Re: UROLOGY NETWORK OF NM

610 Broadway Blvd. NE

Approval of Permanent Certificate of Occupancy (C.O.)

**Re: Urology Network of New Mexico, 610 Broadway Blvd NE, Grading and
Drainage Plan
Engineer's Stamp dated 9-17-04 (J14-D148)**

#### ENLARGED DRAINAGE DETAIL

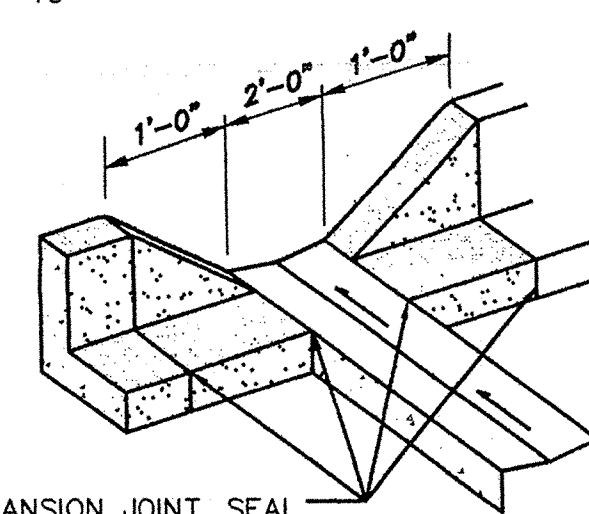
1. Ponding / Water Harvesting is not allowed within the City Right of Way.
2. Please include a copy of the drainage calculations.
3. Where is the proposed storm drain detail referred to in note 17?
